WEST SUSSEX COUNTY COUNCIL CONSULTATION

TO:	Arun District Council FAO: Michael Eastham
FROM:	Stephen Gee Highways, WSCC
DATE:	13/09/18
LOCATION:	Broadlees, Dappers Lane, Angmering, West Sussex, BN16 4EN
SUBJECT:	A/114/18/PL Demolition & erection of 70 bed care home within Use Class C2 (replacing building 4 approved by A/27/16/PL), access, parking, landscaping and other associated works.
DATE OF SITE VISIT:	
RECOMMENDATION:	☒ Advice ☐ Objection ☒ Modification ☐ No Objection ☐ More Information ☐ Refusal
S106 CONTRIBUTION TOTAL:	£ See below for breakdown.

Appendix E – Proposed Pedestrian Infrastructure

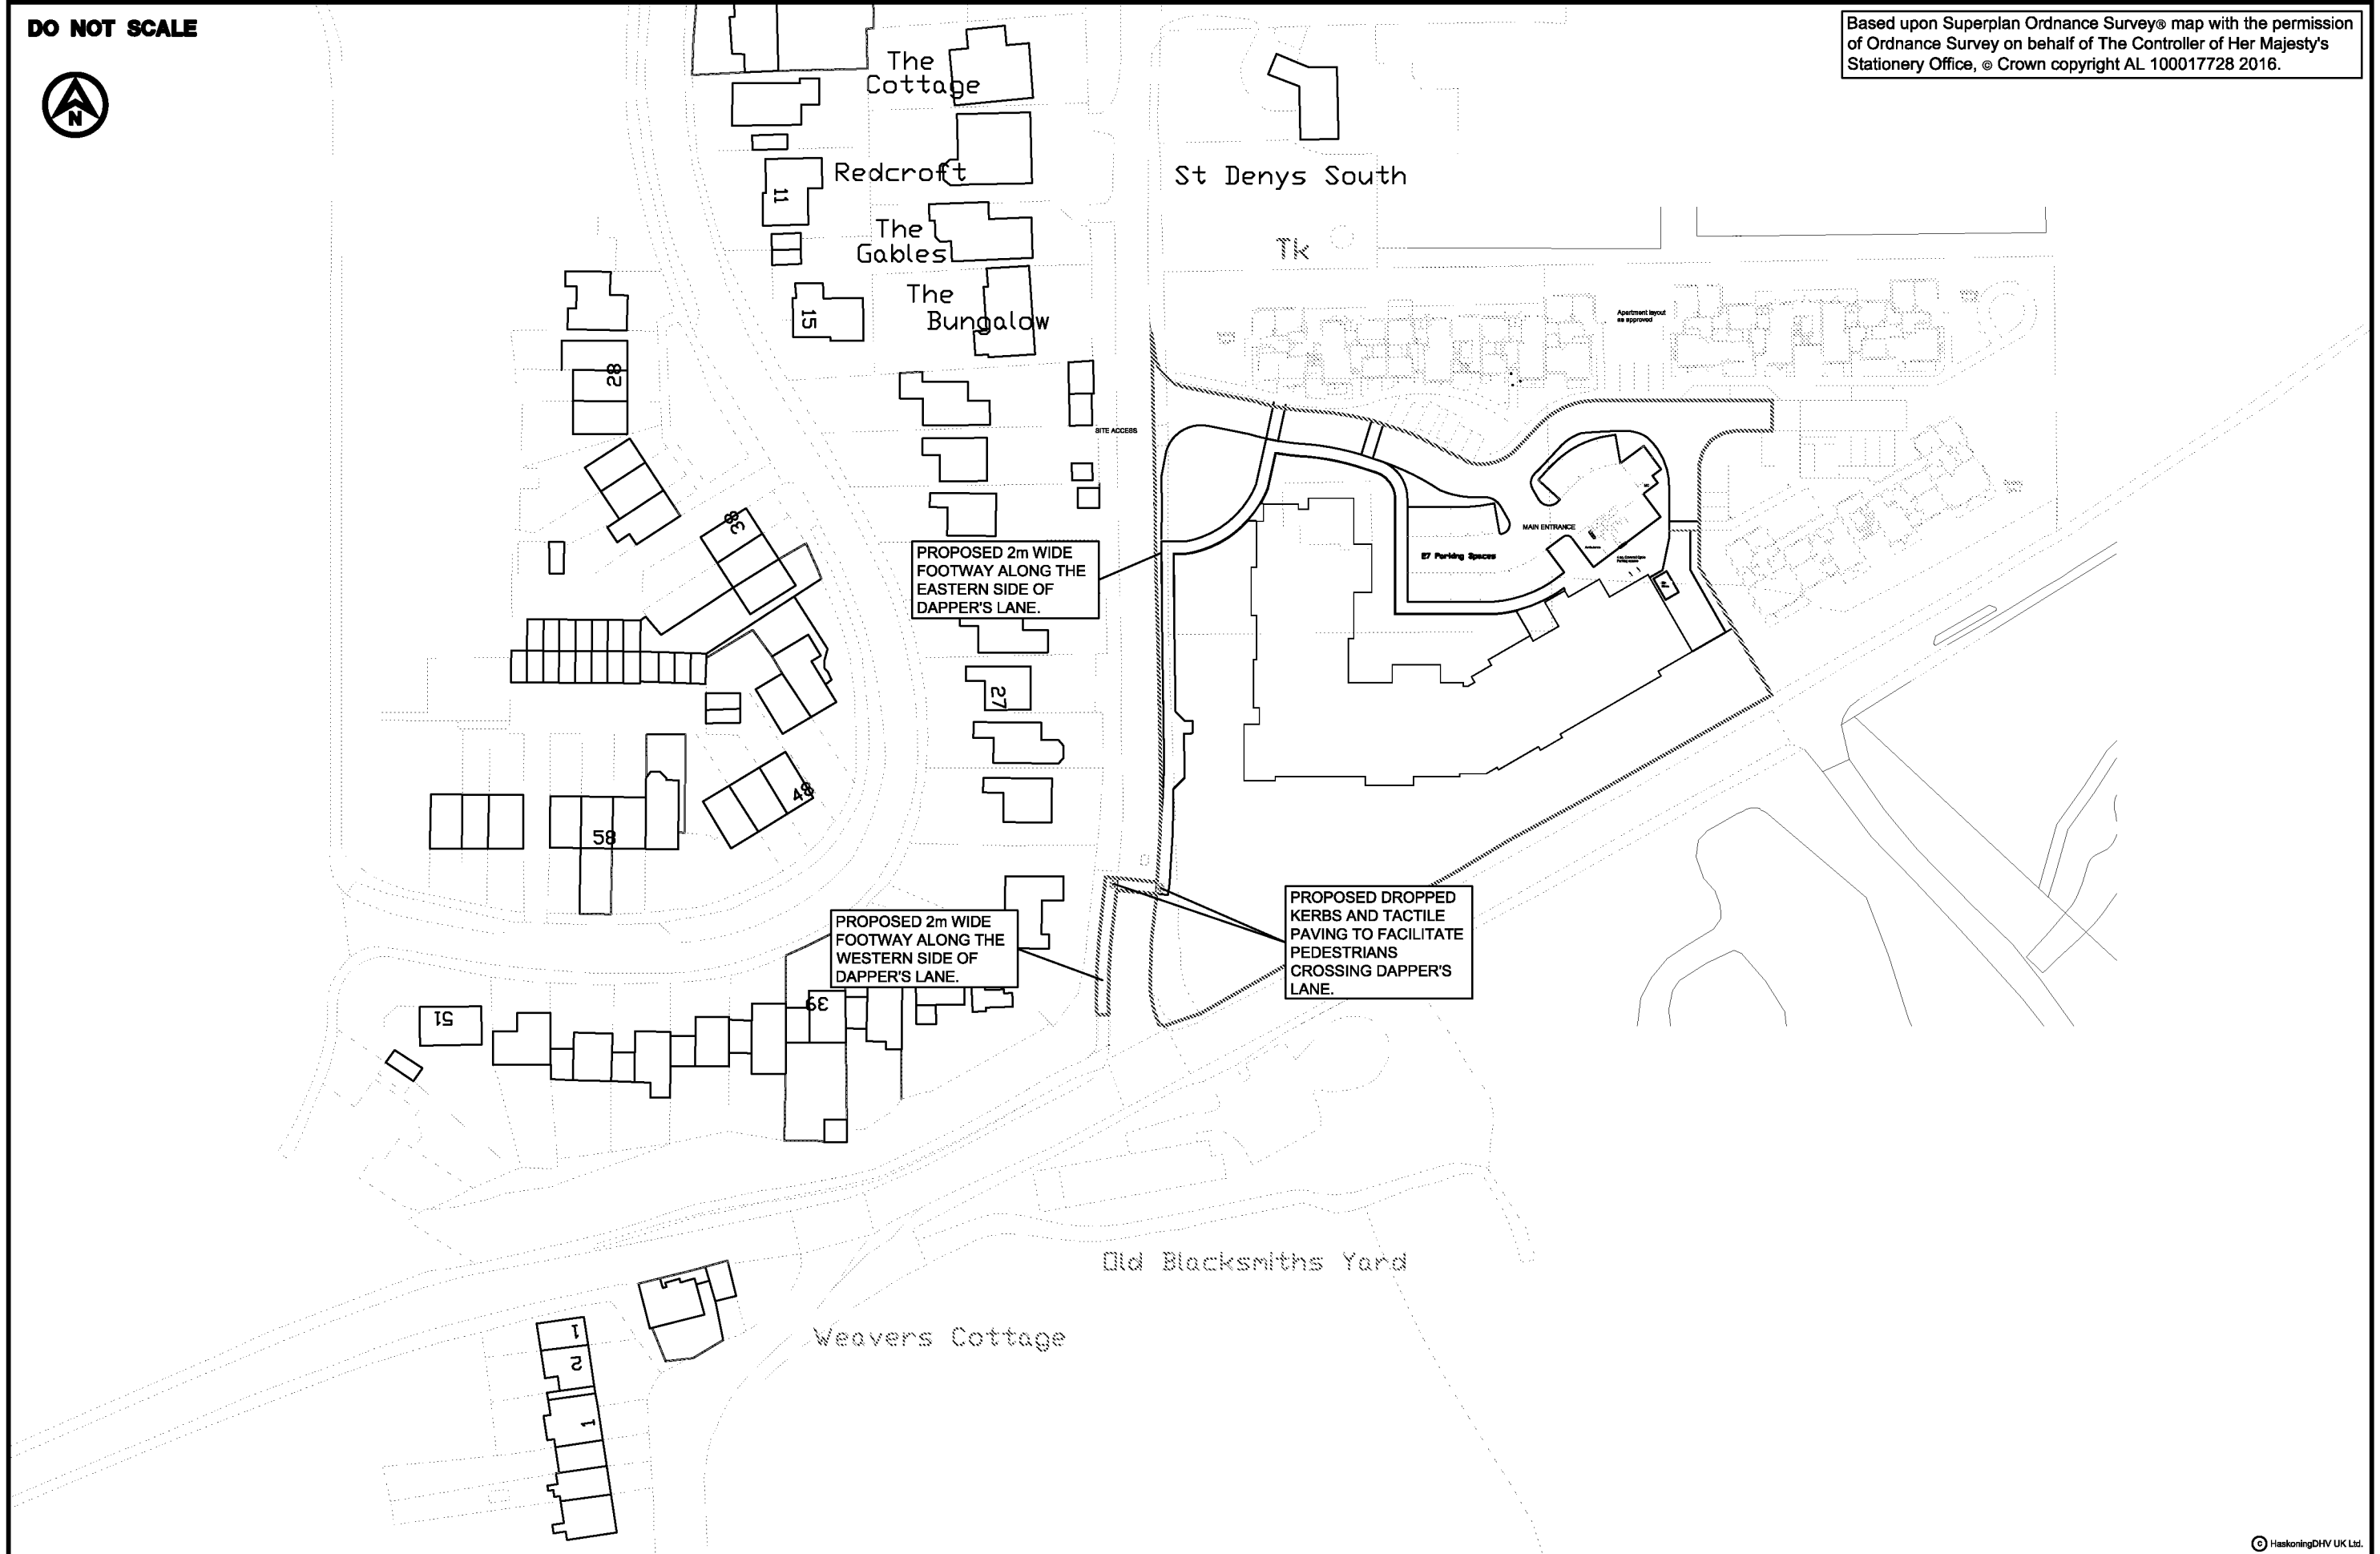
As part of the consented development the applicant is to provide a 2.0m footway from the site access south alongside the existing grass verge and informal pedestrian crossing with tactile paving, dropped kerbs before extending further south on the eastern side of the carriageway to meet the existing provision. (as shown on drawing PB7693-SK01)

It is noted that a number of Trees with preservation Orders (TPOs) are located close to the southern boundary of the site and at points may require deviation into the site.

It is recommended that the proposals are modified to include provision of a footway along the southern boundary of the site (both red and blue line boundary) and the travel plan is revised to incorporate the above comments.
